Ribble Valley Borough Council  
Development Control

Application no: 3/2019/1036

Address: Betty Barn, Slaidburn Road, Waddington

Proposal: Conversion of Barn to Residential Dwelling

C.D.M. REGULATIONS 2015

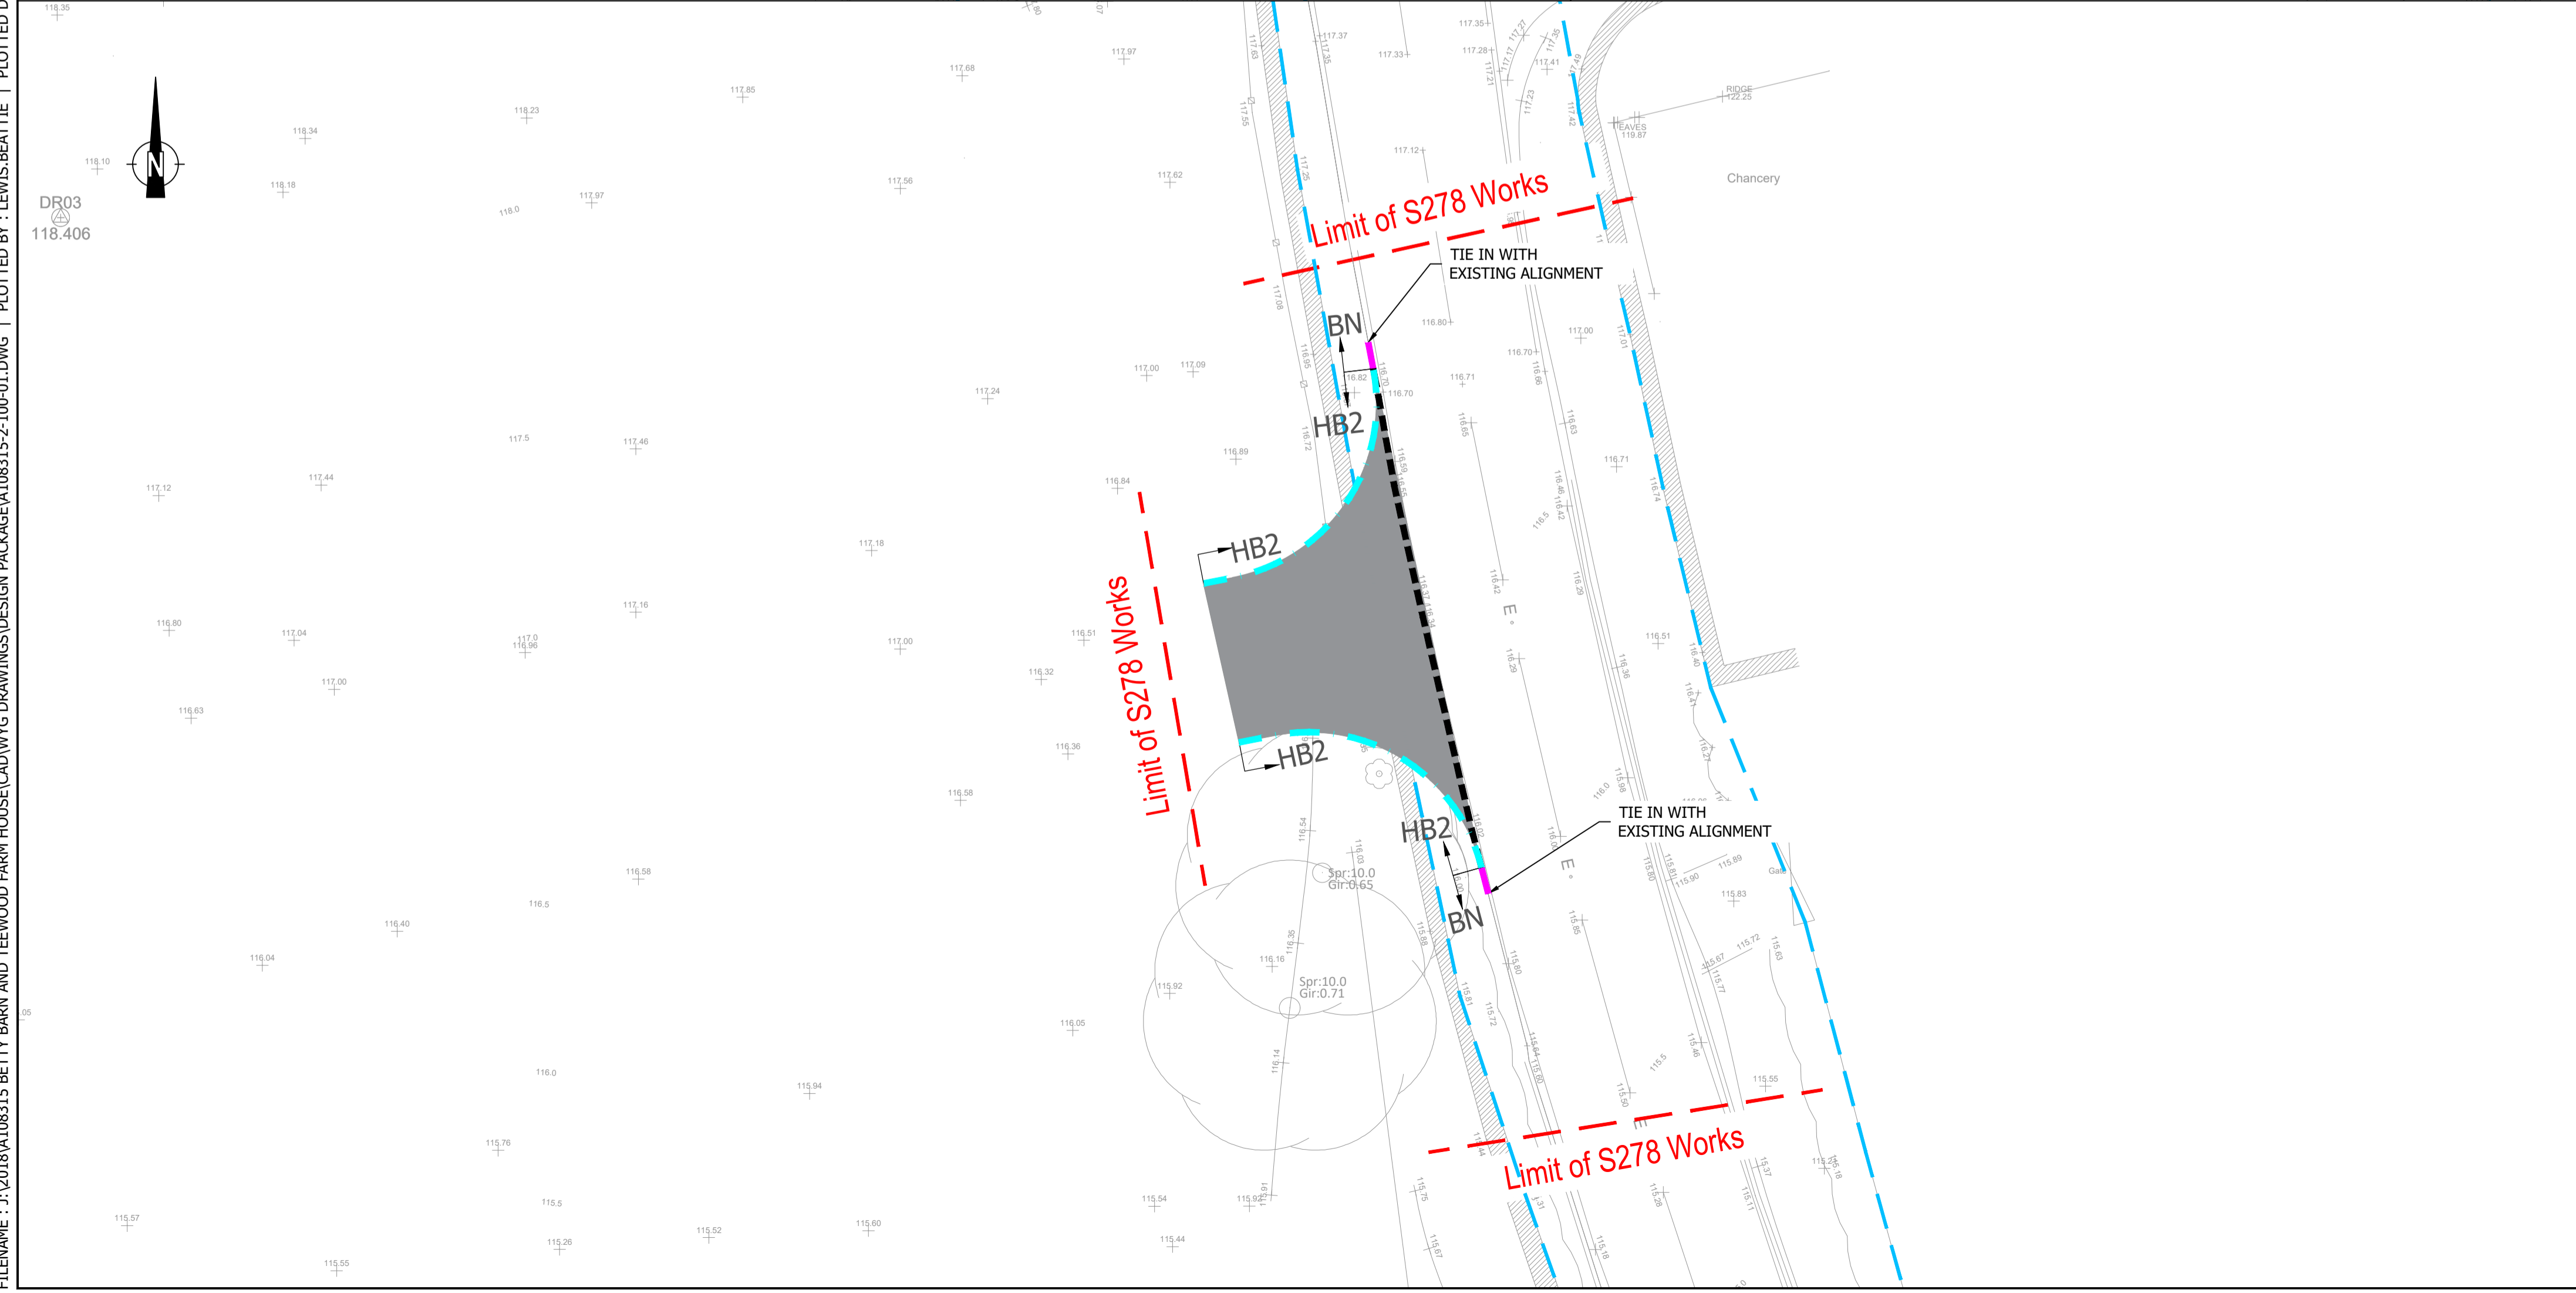
The proposal has been the subject of some discussion between the applicant and the highway authority under the pre-application process. There are inherent benefits in relocation the existing access to the proposed location and this would be considered acceptable to serve the existing users and the additional dwelling. On this basis I would raise no objection to the proposal on highway grounds subject to the following conditions being attached to any planning permission that may be granted

1 Before the access is used for vehicular purposes, that part of the access extending from the highway boundary for a minimum distance of 7m into the site shall be appropriately paved in tarmac, concrete, block pavements, or other approved materials. Reason: To prevent loose surface material from being carried on to the public highway thus causing a potential source of danger to other road users.

2 Notwithstanding the provisions of the Town and Country Planning (General Permitted Development) Order 1995 there shall not at any time in connection with the development hereby permitted be erected or planted or allowed to remain upon the land hereinafter defined any building, wall, fence, hedge, tree, shrub or other device over 1m above road level. The visibility splay to be the subject of this condition shall be that land in front of a line drawn from a point 2.4m measured along the centre line of the proposed road from the continuation of the nearer edge of the carriageway of Slaidburn Road to points measured 70m to the north

and 100m to the south along the nearer edge of the carriageway of Slaidburn Road, from the centre line of the access. Reason: To ensure adequate visibility at the site access onto Slaidburn Road.

- 3 The existing access shall be physically and permanently closed with vehicular access being prevented by the erection of a boundary wall. The existing verge of the vehicular crossing shall be reinstated concurrent with the formation of the new access. Reason: To limit the number of access points to, and to maintain the proper construction of the highway
- 4 The proposed access from the site to Slaidburn Road shall be constructed to a (minimum) width of 5.5m and this width shall be maintained for a minimum distance of 7m measured back from the nearside edge of the carriageway. Reason: To enable vehicles to enter and leave the premises in a safe manner without causing a hazard to other road users.
